Proposed Redevelopment of the Eastlakes Shopping Centre Site

Review of Traffic & Parking Matters

Prepared by
Fred Gennaoui

on Behalf of Department of Planning

Redistributed Thursday morning peak hour traffic flows plus development traffic

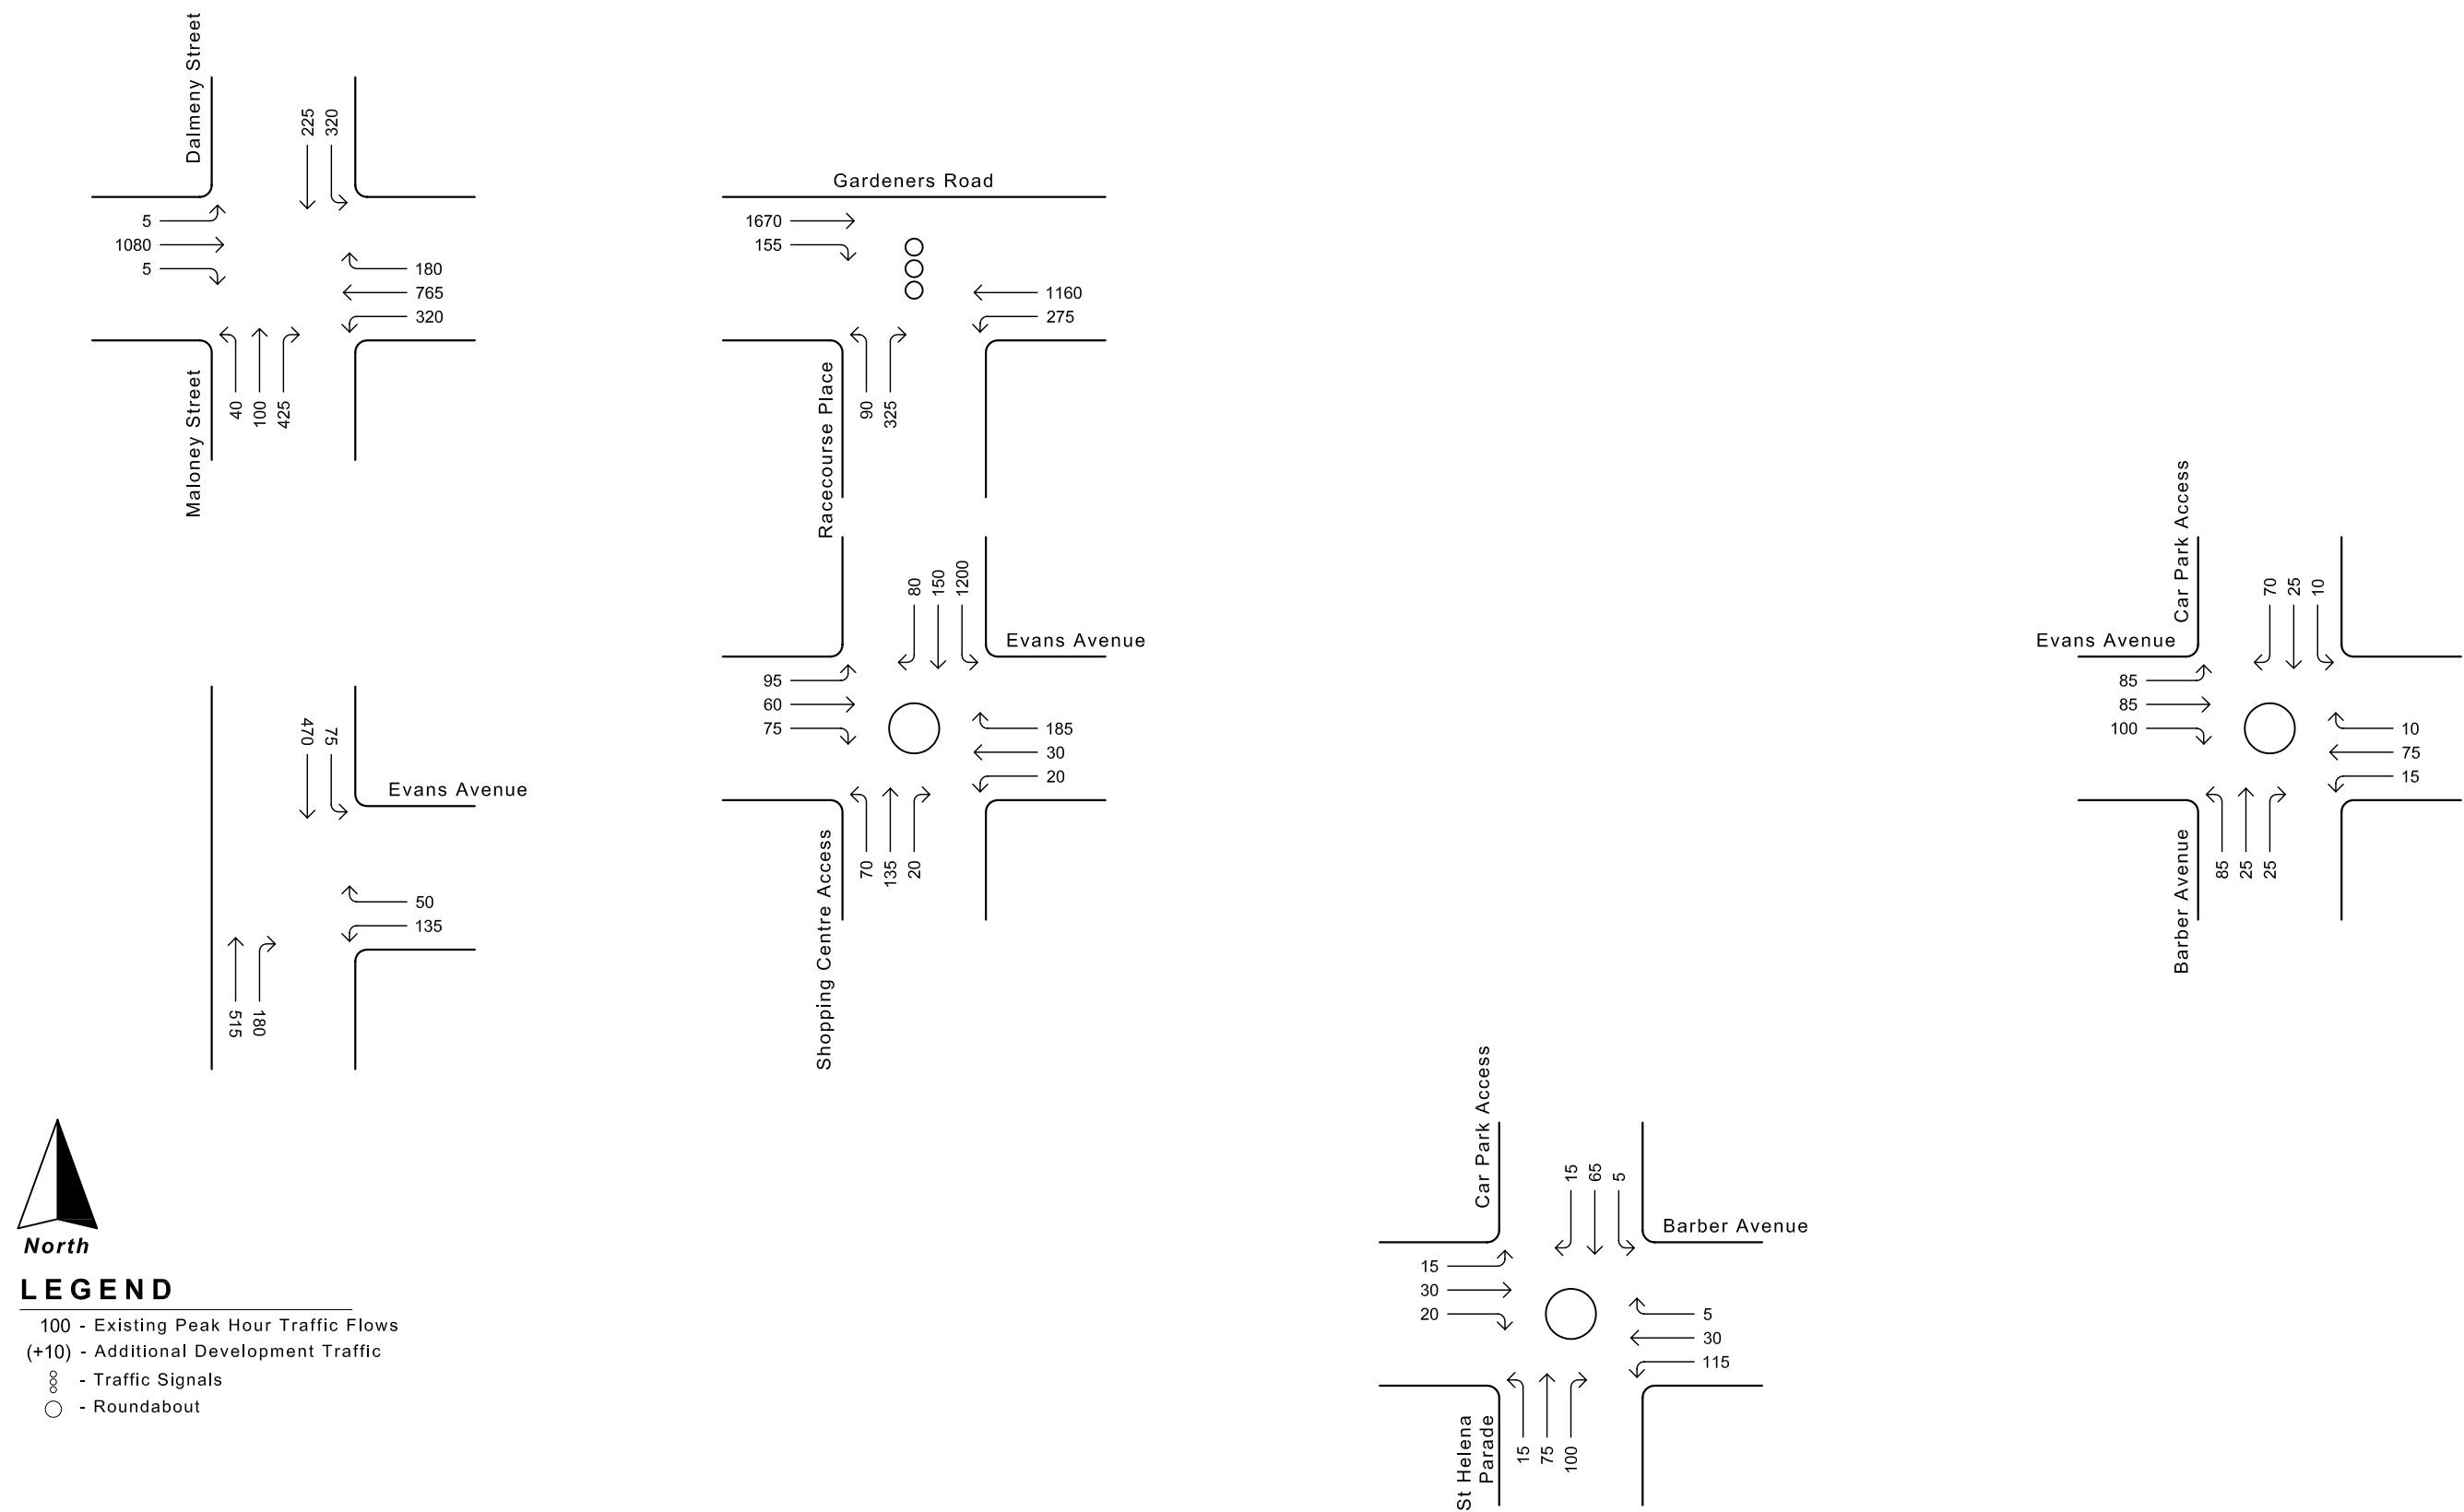
It is considered that these proposed access arrangements, which are currently required, would provide much better and safer access into a redeveloped site. Existing traffic volumes accessing the Centre, shown in Figures 2 and 3 of CBH&K report, would be redirected as shown in Figures 4 and 5 of the report. The redirection made by CBH&K of the existing traffic and the assignment of the additional traffic is considered reasonable.
